Reference: H09-0192-20 **Date of Decision:** 22nd April 2020

Location: Land At Holbeach Drove Gate (Site On Corner Of Holbeach Drove & B1166)
Holbeach Drove Spalding Lincs

Description: Erection of 3 bed detached house with on site parking

South Holland District Council hereby give notice that this application has been REFUSED for the above proposal for the following reason(s):

V3393-11

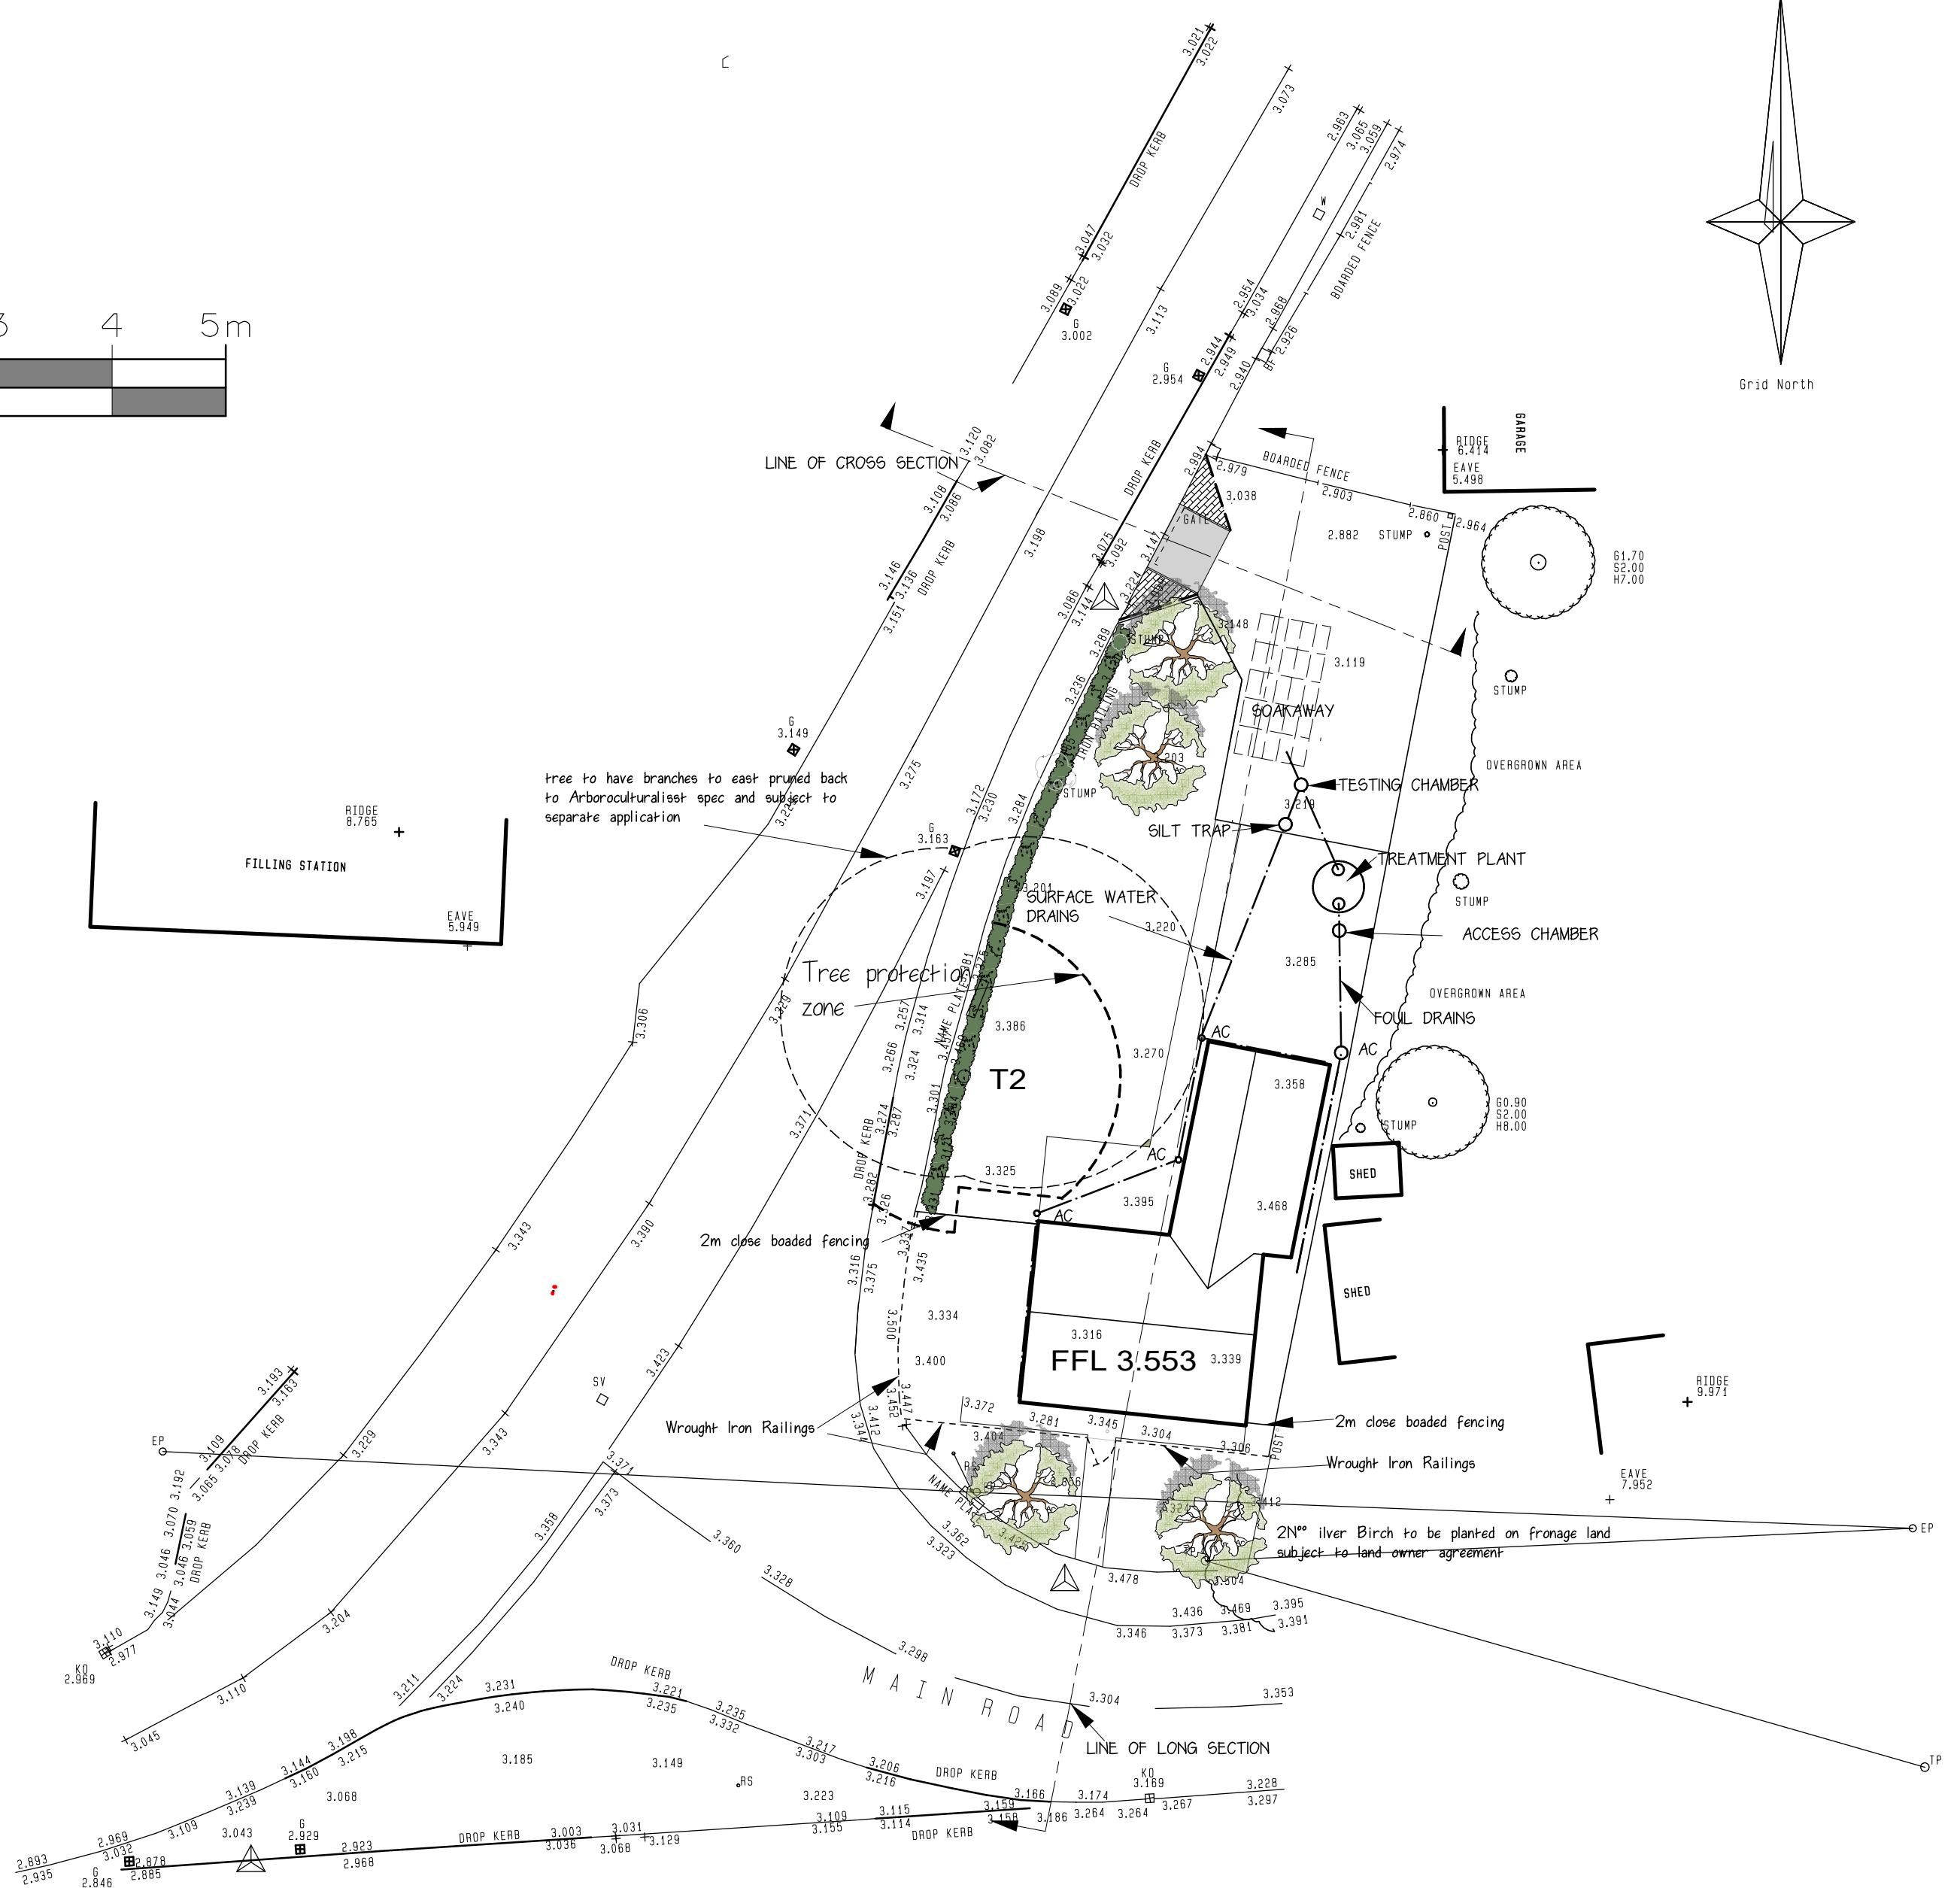
- 1 The footprint of the proposed dwellinghouse has been reduced in comparison to that previously refused under planning application ref. H09-1025-19. Notwithstanding this, no variation has been proposed for the separation distances between the house and the southern boundary abutting Drove Road.

Although the design and appearance of the proposed dwelling is not out of character with existing built development in the surrounding area, the proposed layout is such that the house would still be positioned in such close proximity to Drove Road that it would increase its prominence on the wider street scene, particularly when viewed from Drove Road to the east, to the extent that it would adversely impact upon the character of the area.
